Your Ref: OWPC21098
Our Ref: EP/160/18/PL 02-11-2018
Please ask for:
Mr J Baeza

Variation of condition No.3 imposed under planning reference no: EP/45/17/HH relating to the proposed materials

11 Beechlands Close East Preston

Roof Plan (1:100)

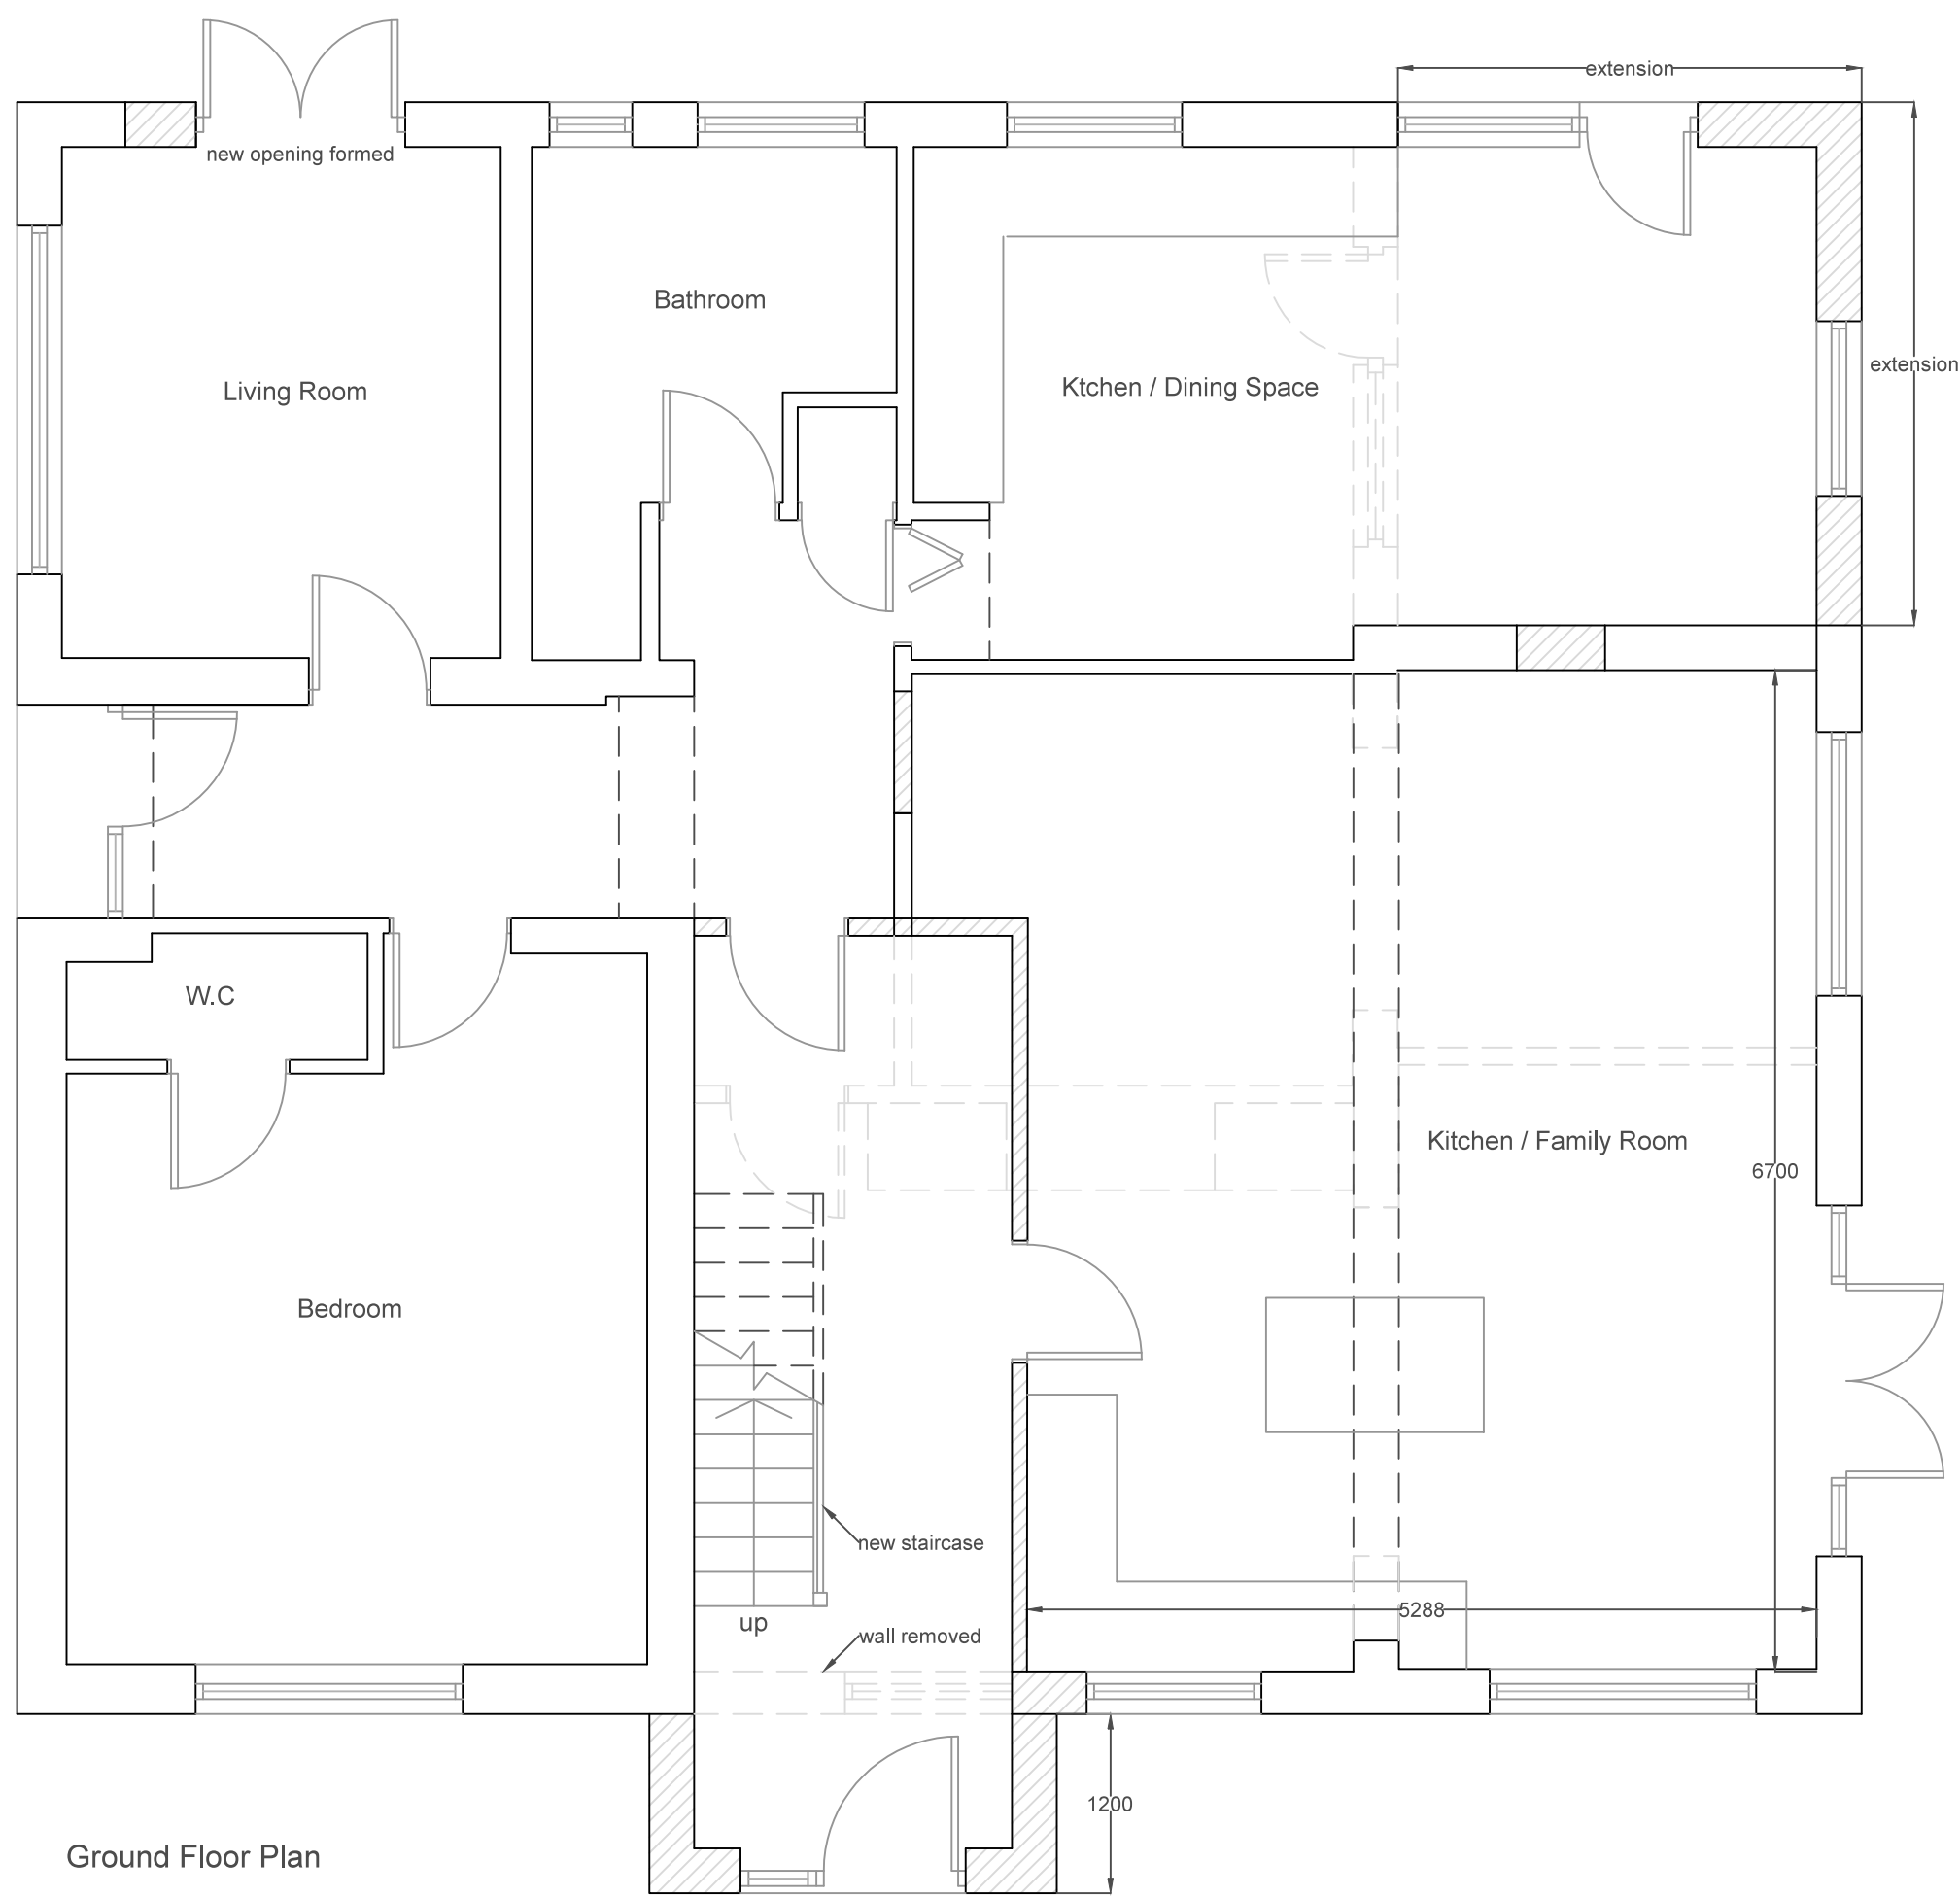
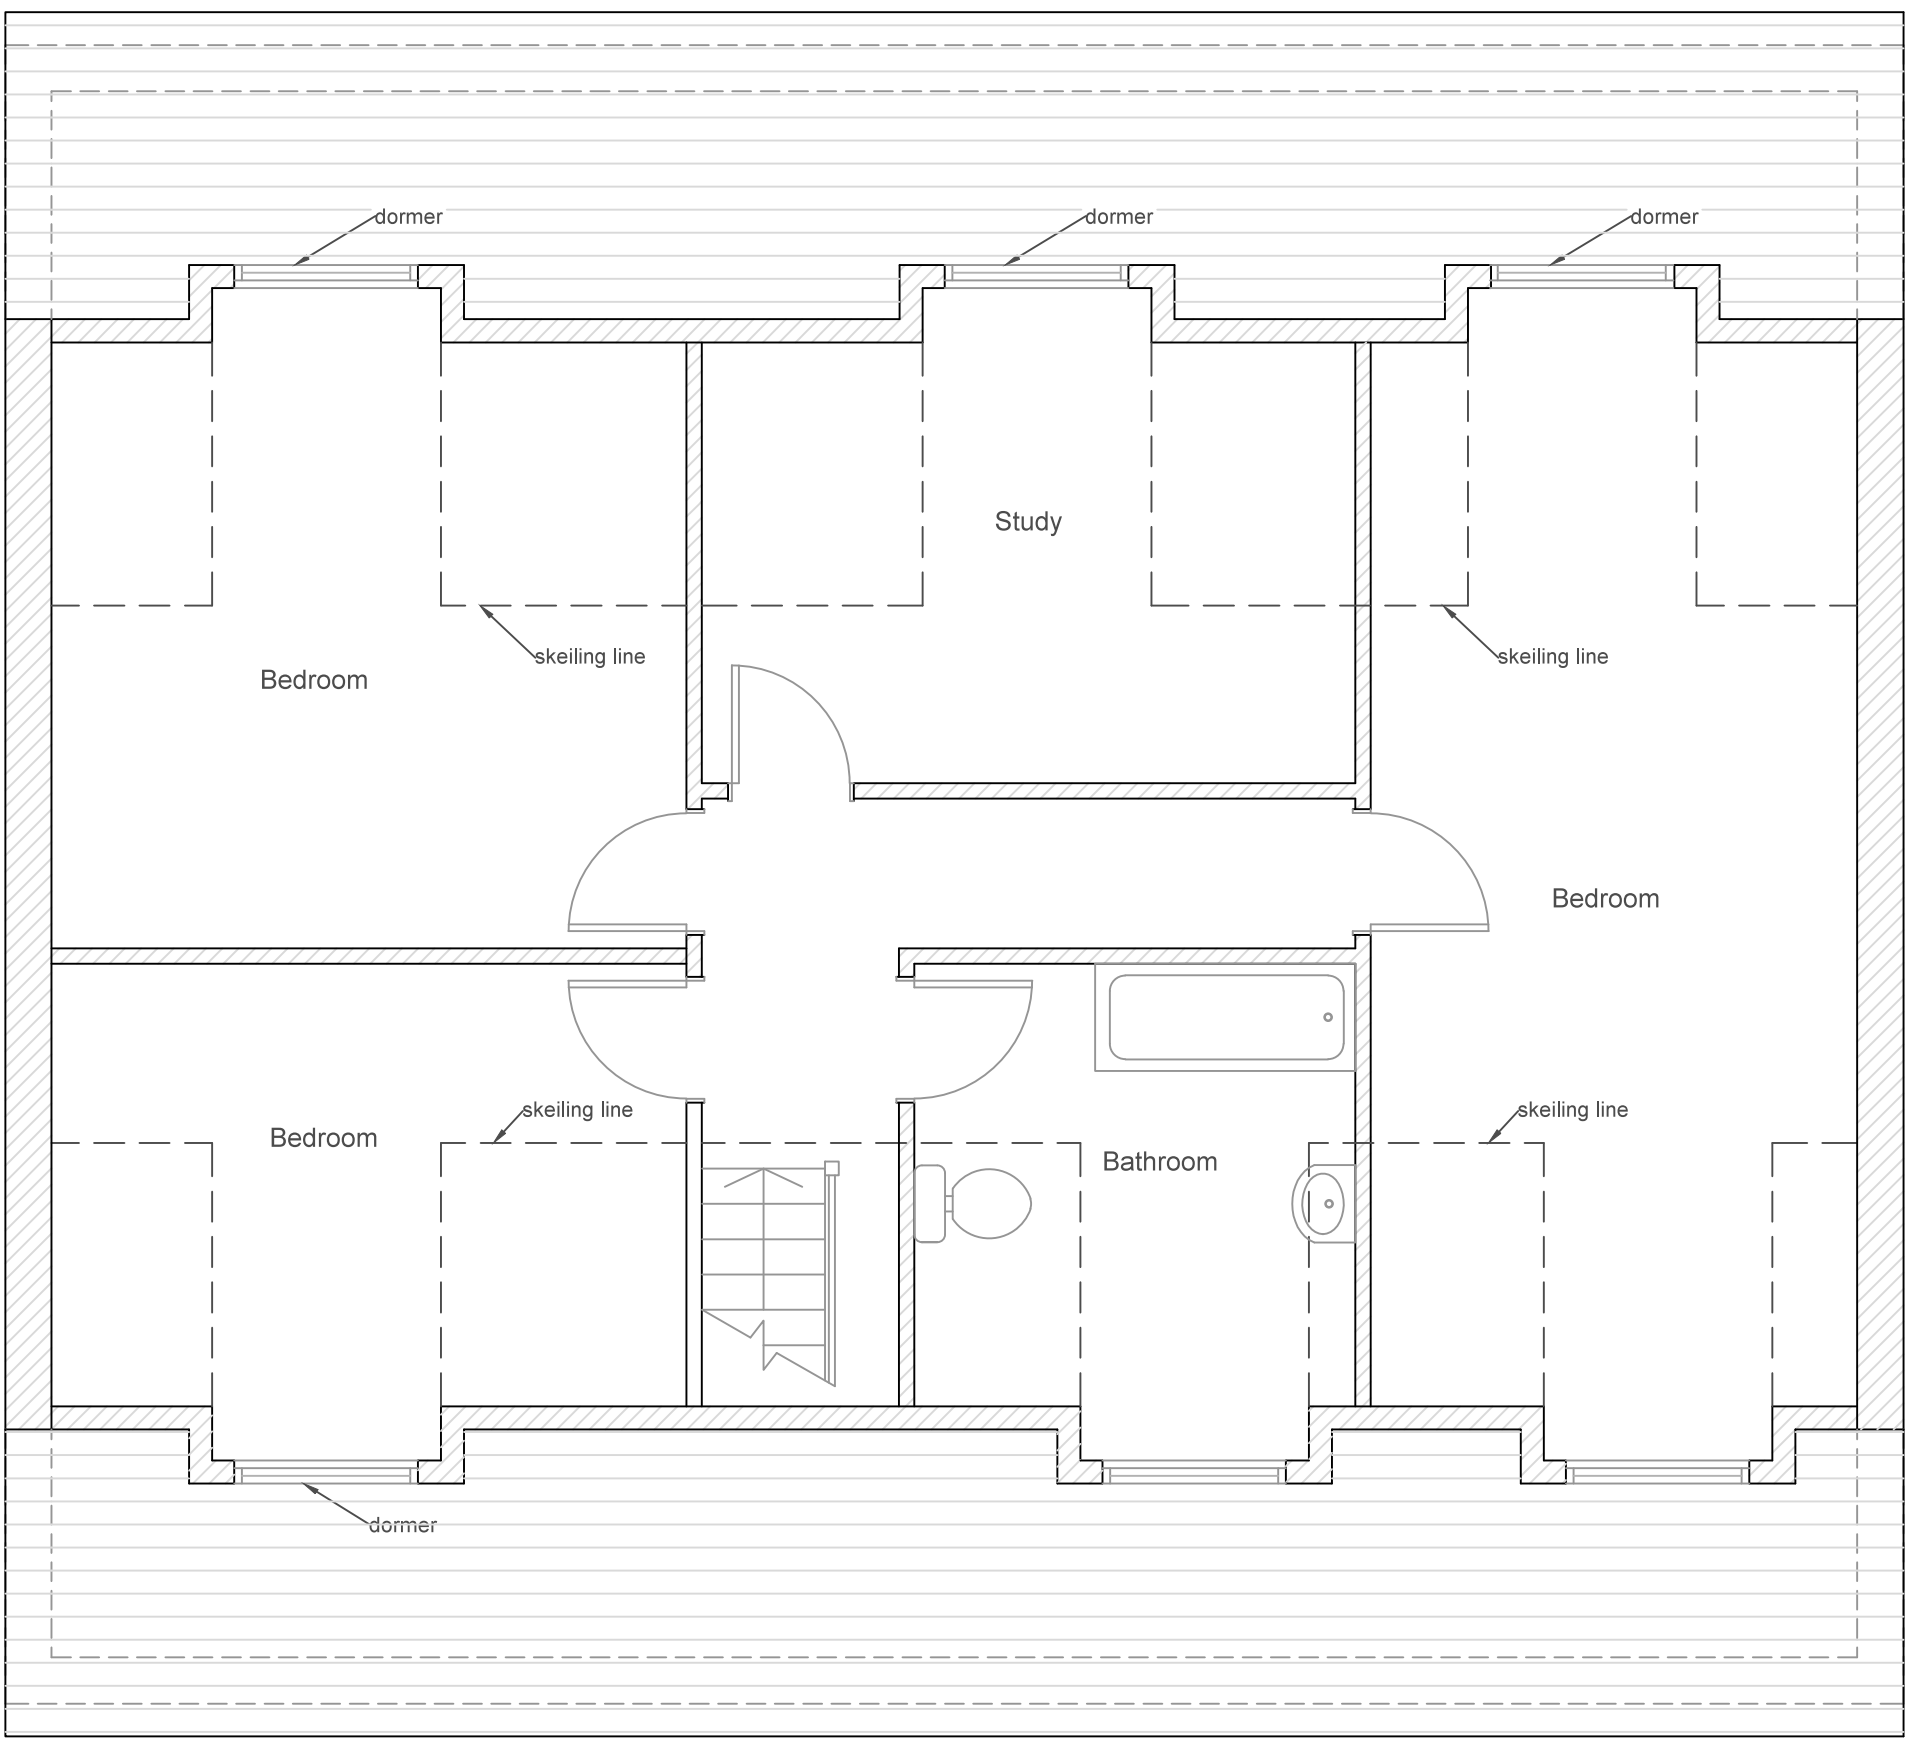
This condition is clear and explicit. The applicant has instead roofed the house with grey tiles which do not match the tiles previously used and are alien to the surroundings. The fact that the roof has been tiled with these tiles before this planning application could be considered suggests that the applicant is daring the Council to tell her to reroof the house.

Proposed Roof Tile – Marley Modern Tile, colour smooth grey.

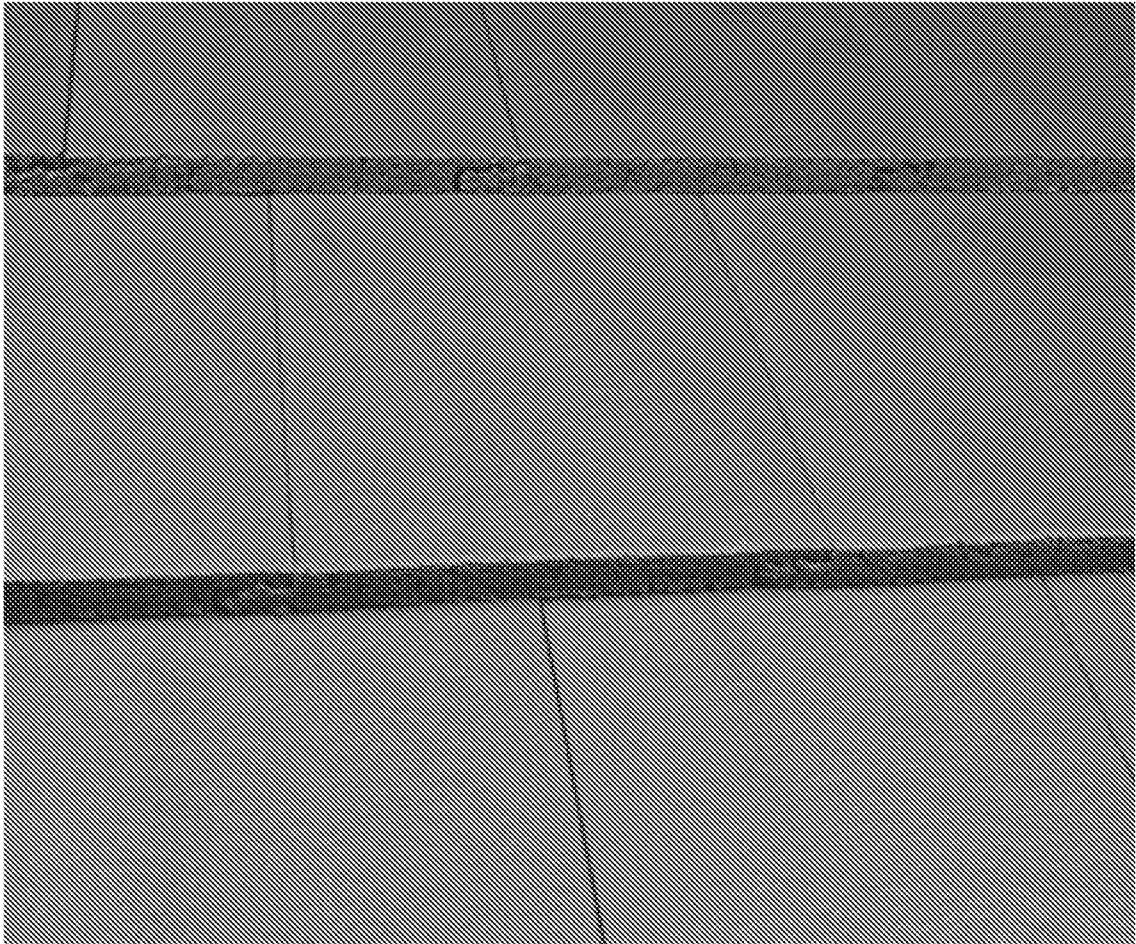
This application for retrospective approval of a change in the roofing materials from the approved colour and style to a different material represents a blatant attempt to override the planning system. Condition 3 of the planning consent for EP/45/18 stated "The materials and finishes of the external walls and roof of the building hereby permitted shall match in colour and texture those of the existing building".

This application represents a blatant attempt to break the planning system. If the system is to retain credibility, this application should be refused, and the applicant should be required to roof the house with tiles which meet the conditions imposed when EP/45/18 was approved. If conditions are imposed, they must be enforced.
